Oulton Parish Council's Response at Deadline 3 following the ISH 3 and ASI 2.

1. Noise and Vibration:

1.1 HDD Noise and Vibration assessments for CCR16B & CCR16C

TITLE  
B1149 OULTON  
DRAFT  
ACC25b ACCESS DESIGN  
(SHEET 2 OF 2)

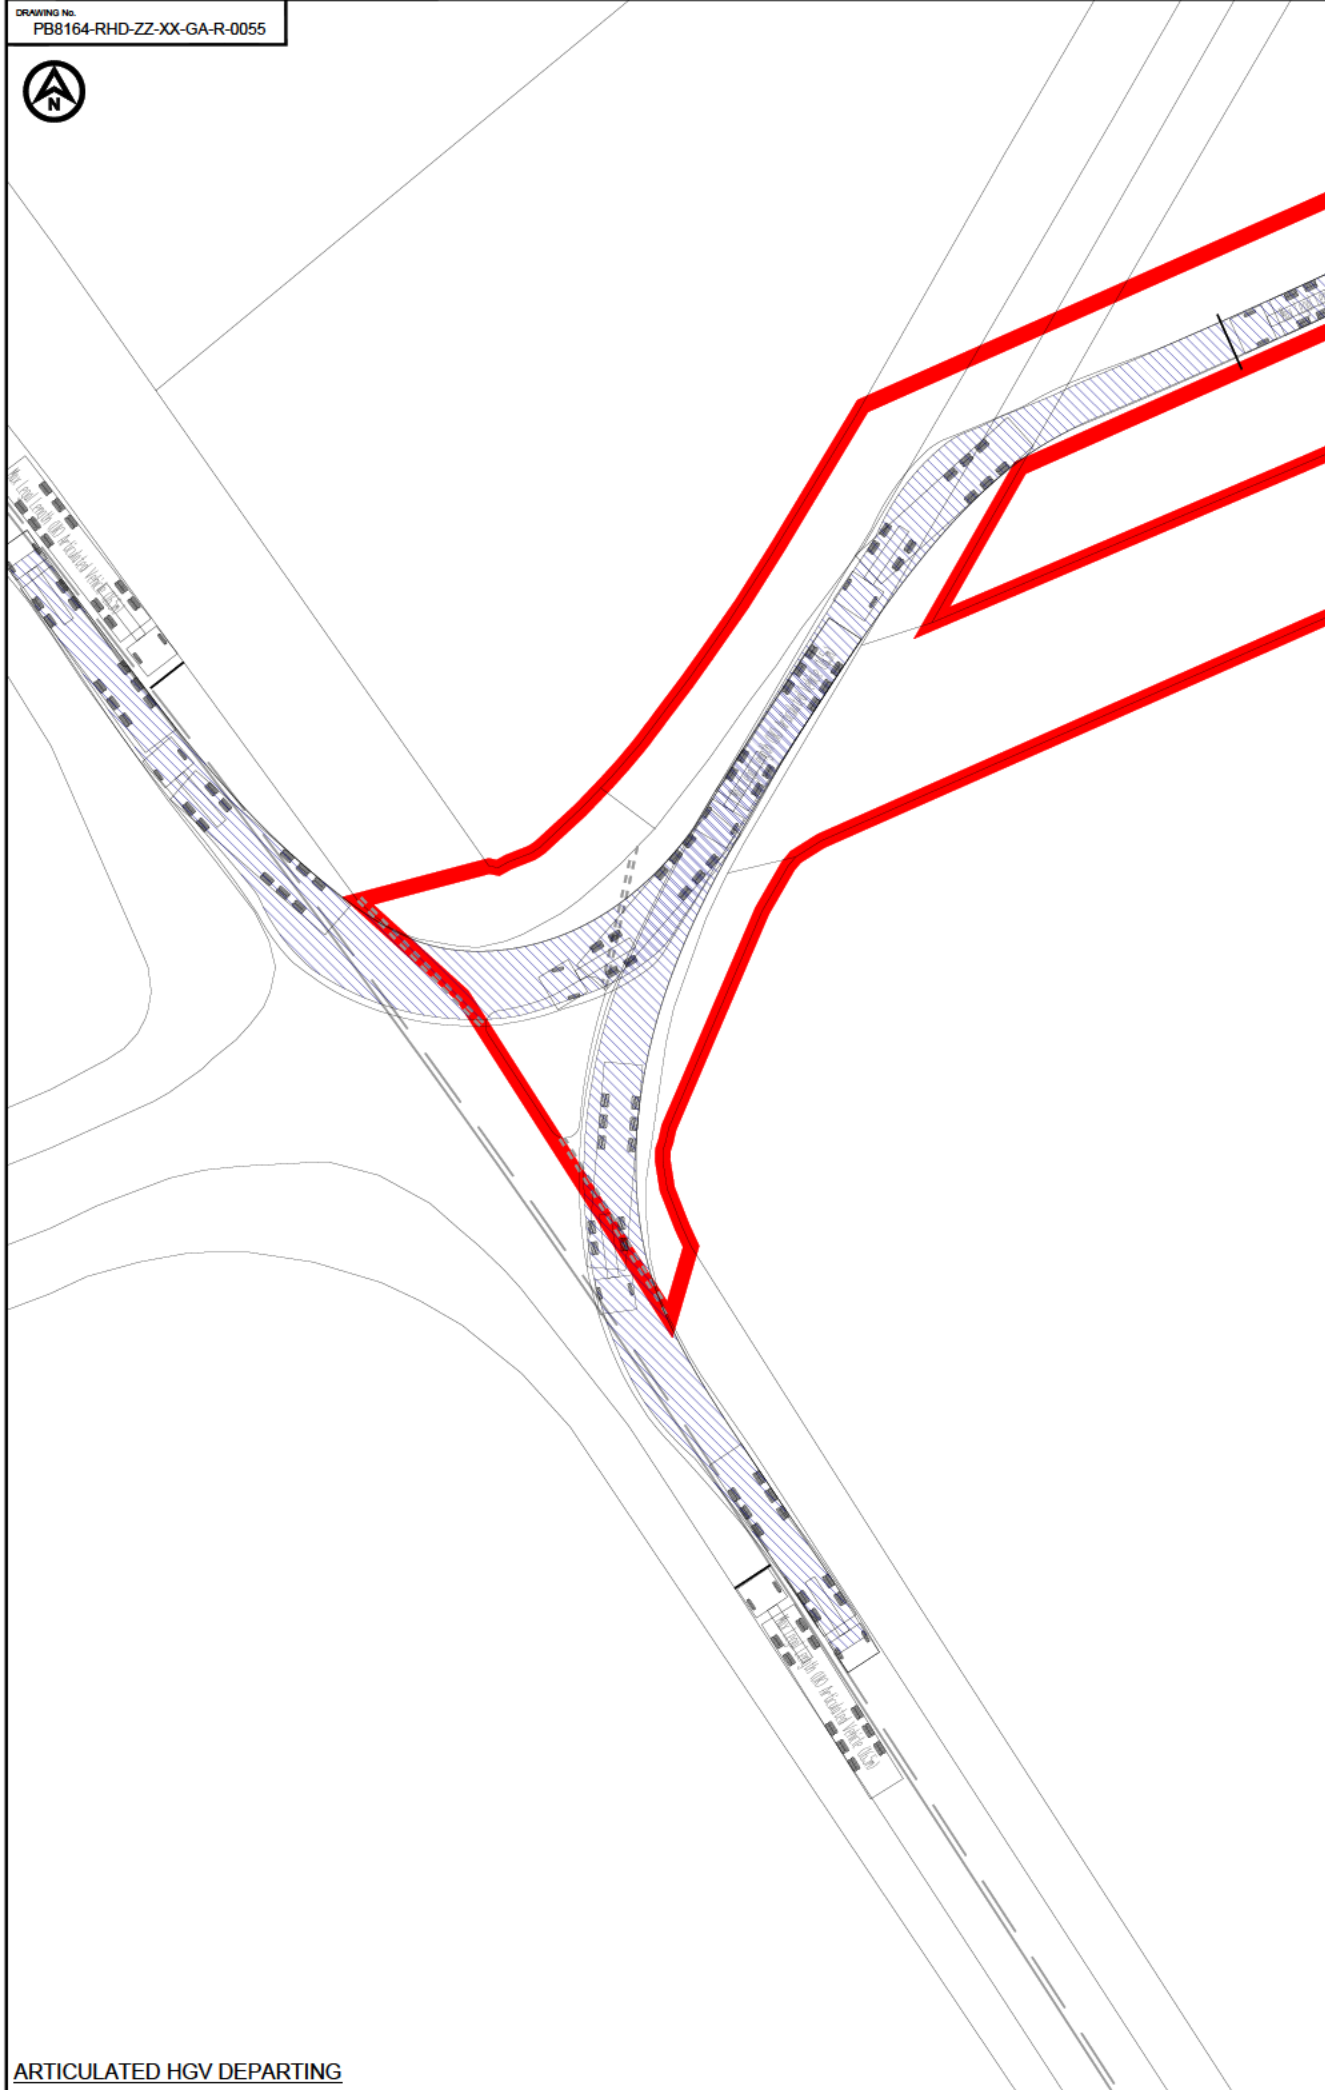
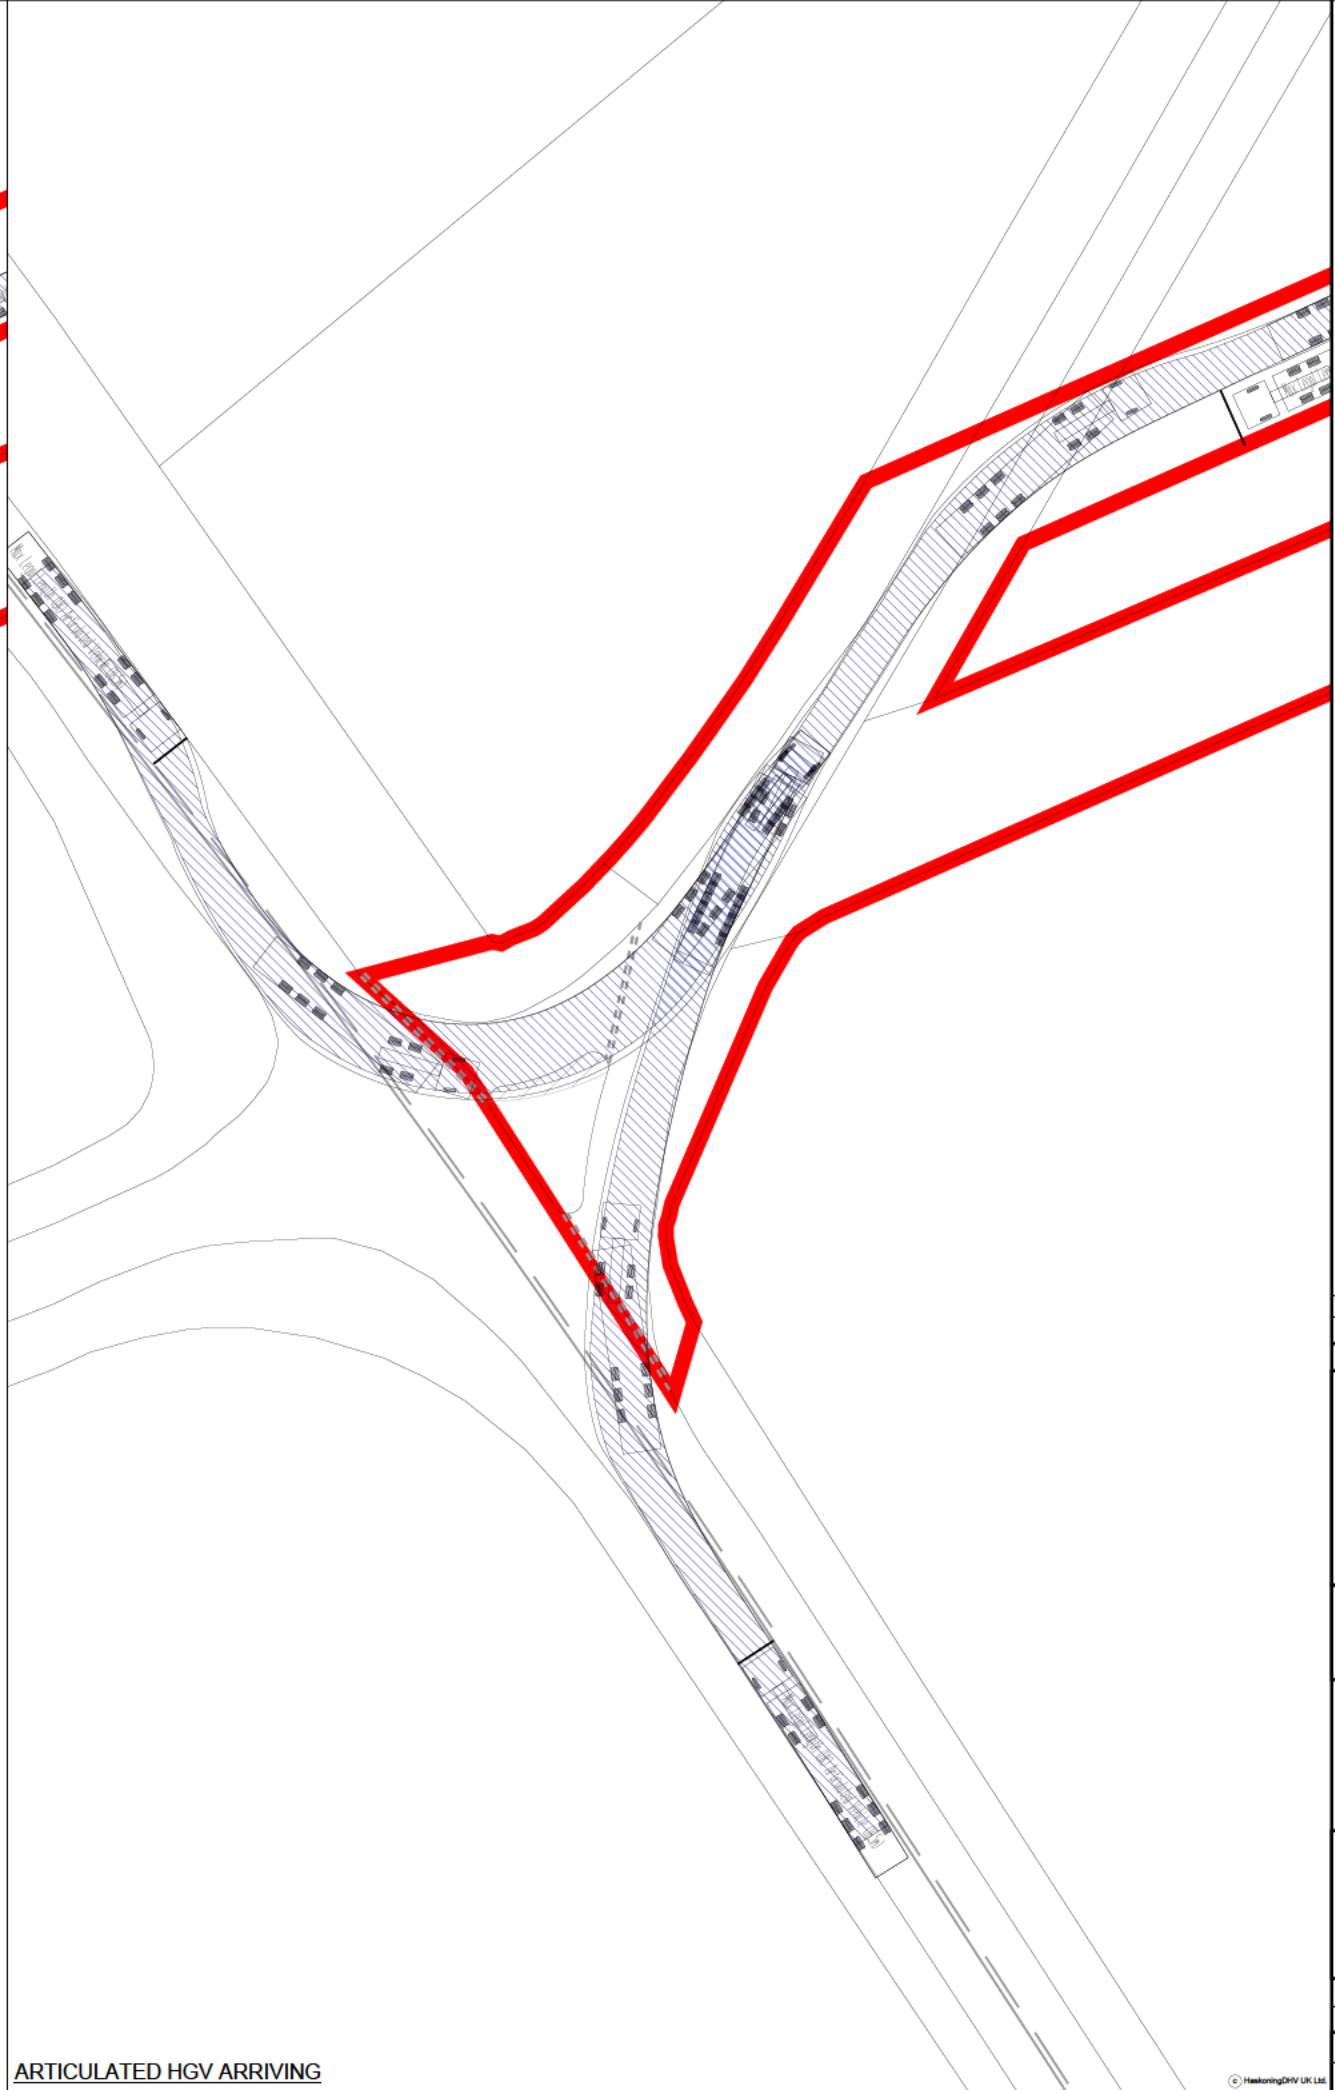
Access **ACC25b** gives access to the cable route and HDD works under the solar farm. NCC stated that at **ACC25b** there would be traffic lights and allowing access from B1149 for a limited period only.

However, there is no written information provided by the applicant as to whether the traffic lights also include **ACC25** into the **temporary compound**.

OPC seeks further clarification on access ACC25 (Temporary Compound) as to whether the temporary compound will be in situ for 12-18 months?

If so, would this go against the definition of a 'limited period' for an access off the B1149, as defined by NCC Highways?

Will both access ACC25 and ACC25b be in use at the same time?
